**Consultation Response from KC,
Highways Development Management**

2024/92016 Land Adjacent, The Shears, 201, Halifax Road, Hightown, Liversegde, WF15 6NR

Discharge of details reserved by conditions 5 (materials), 6 (boundary treatment), 7 (Phase I Desk Top Study), 12 (bin storage/locations), 13 (evc) on previous permission 2023/93657 for erection of two detached dwellings with detached garages; alterations to public house with dwelling above to form one dwelling; erection of single and two storey extension to 201a Halifax Road

Drawing No.
3571 (0-) 15

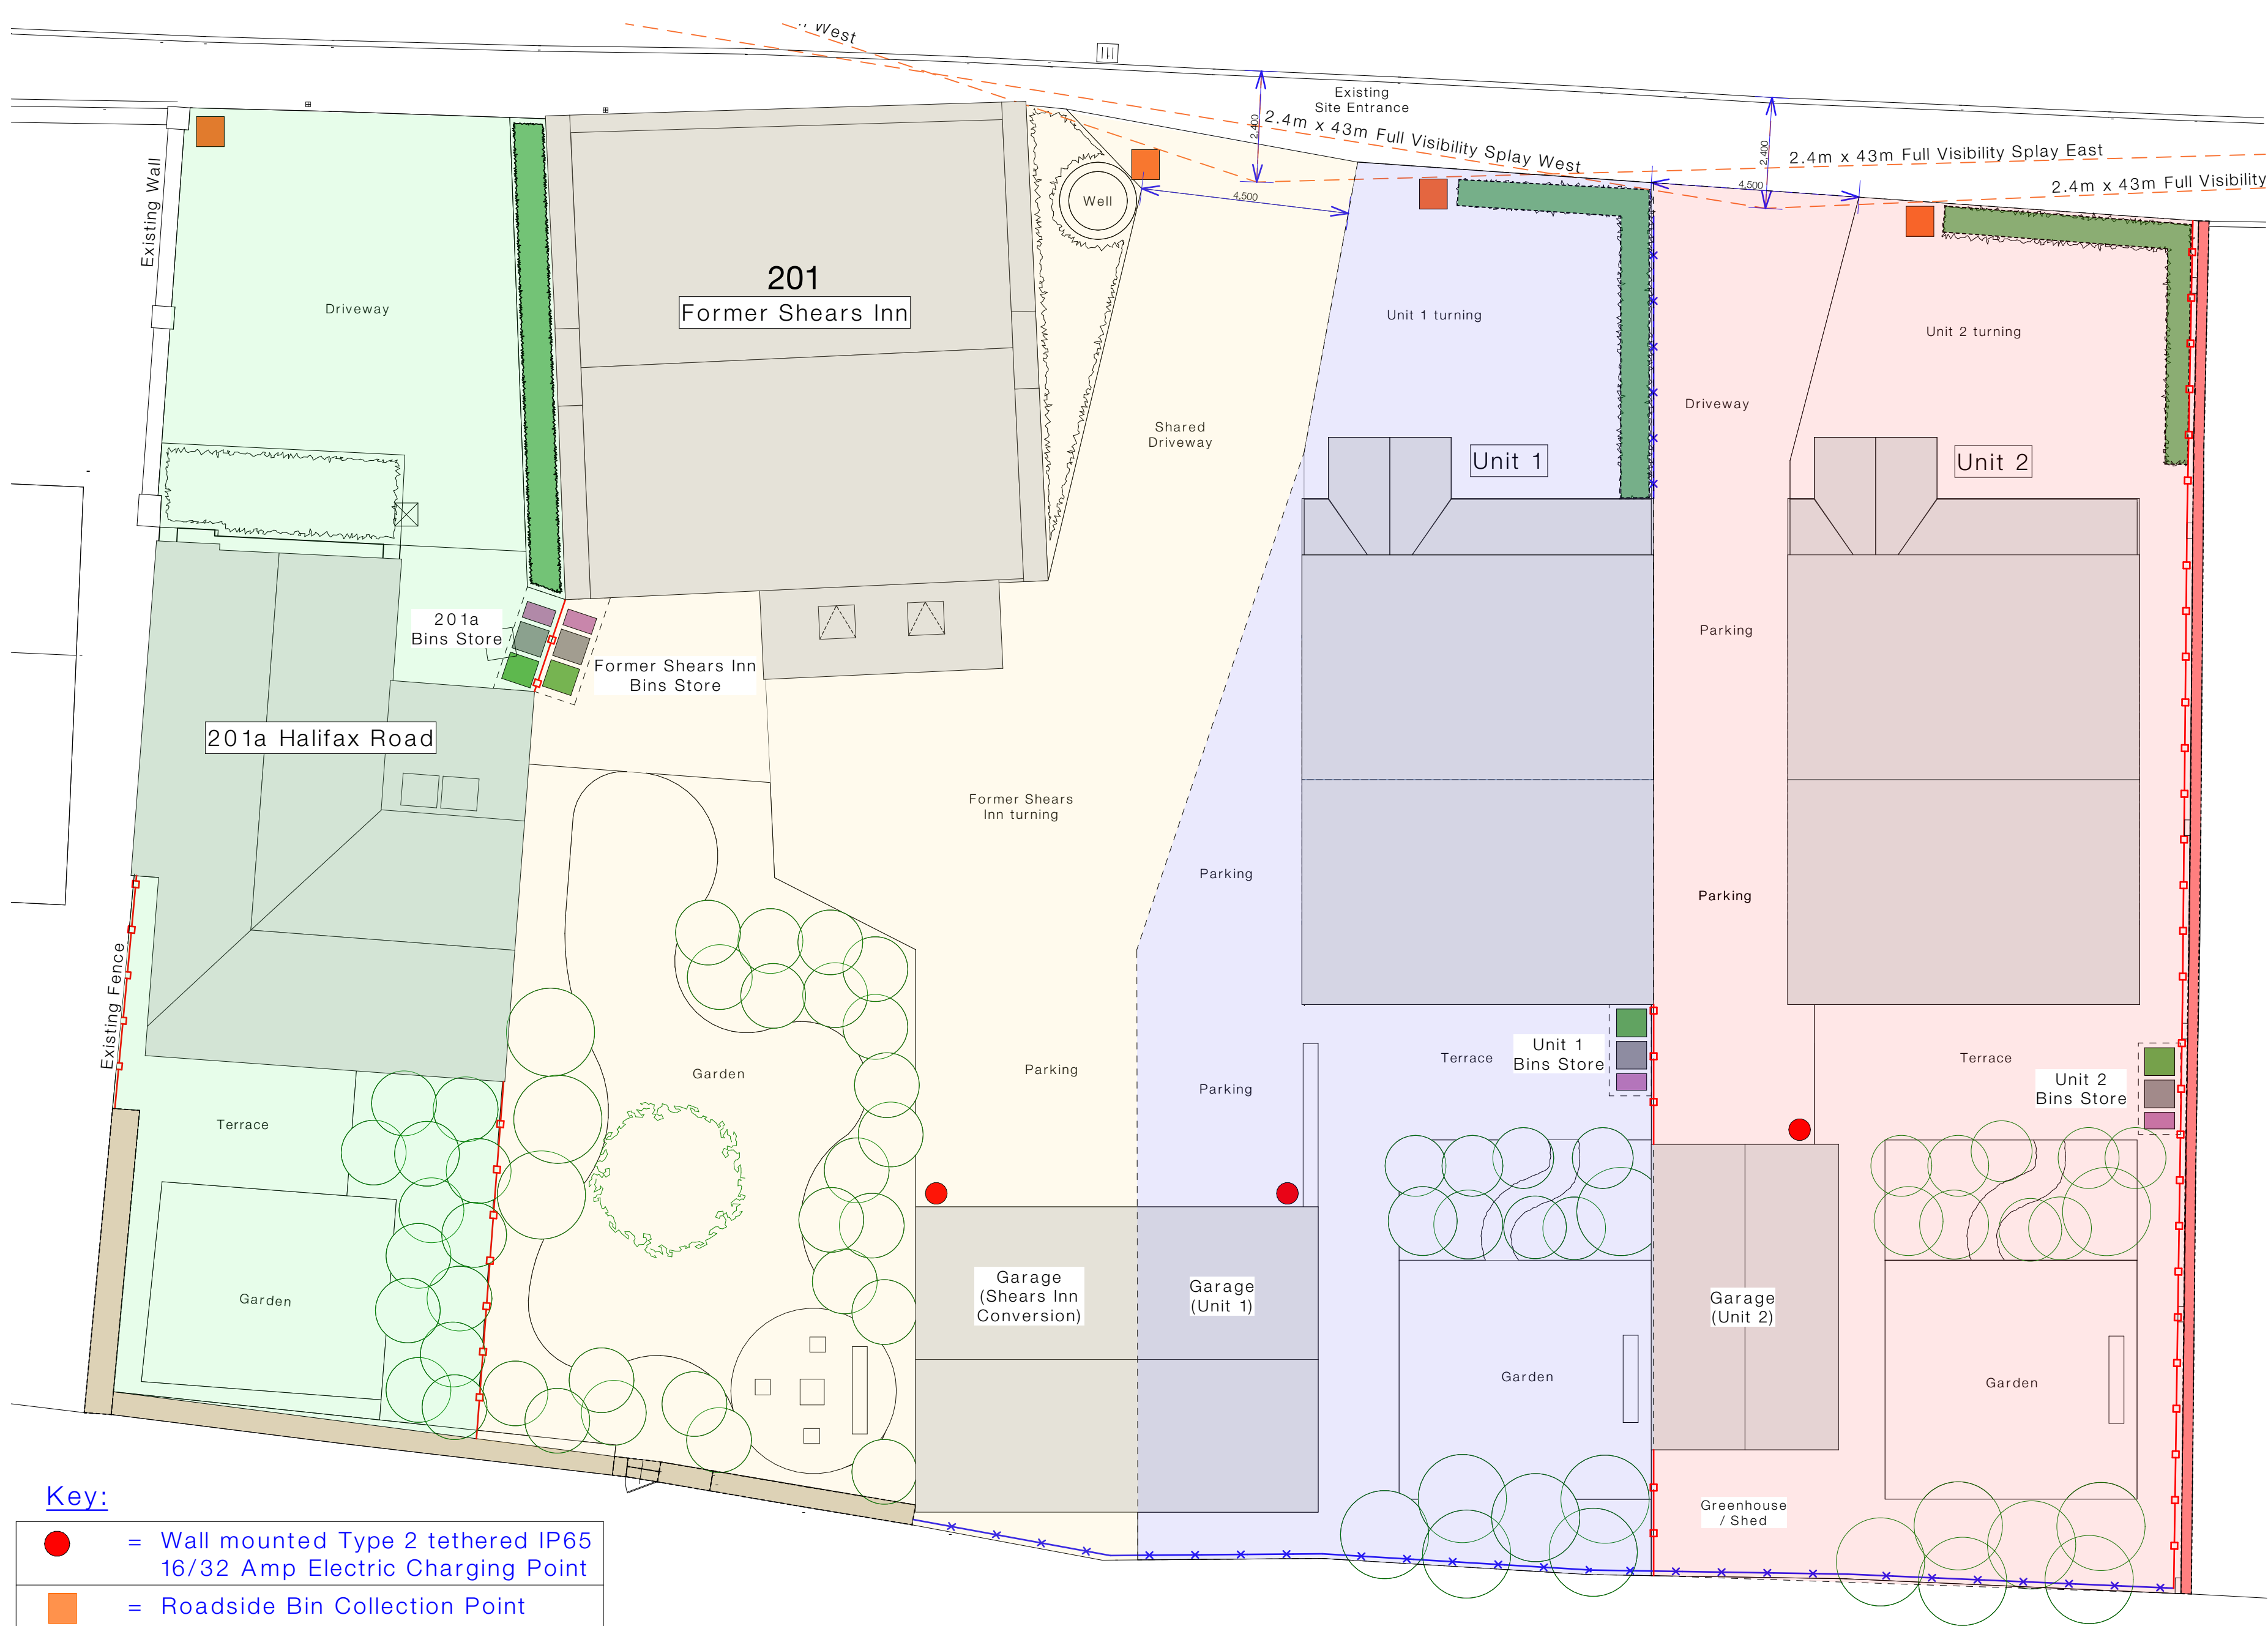
Drawing No 3571 (0-) 15 Revision A has identified suitable locations for the bin storage and collection points.

The drawings as submitted are therefore acceptable and condition 12 can be discharged.
